Your Ref: OWPC23150
Our Ref: R/87/19/HH 16-04-2019
Please ask for:
Zac Denton

Side extension and rear extension replacing and extending conservatory allowing internal layout changes.

45 Chaucer Avenue Rustington

Proposed Front Elevation

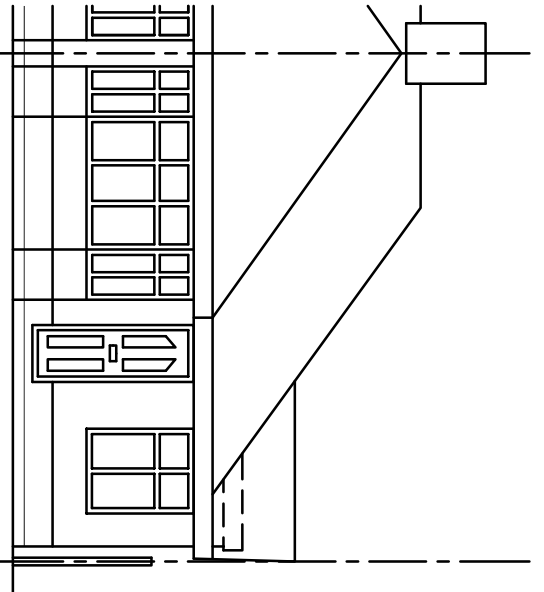
I support this application however I do have concerns about how the exterior of the extensions will look. My kitchen window is very close to the front side extension and I would prefer the exterior finish to be white to keep the small enclosed area by my front door and kitchen window as light as possible. Also, I would like reassurance the rear extension will be finished to a good standard and not just a grey breeze block wall as this will be very visible from my rear garden.
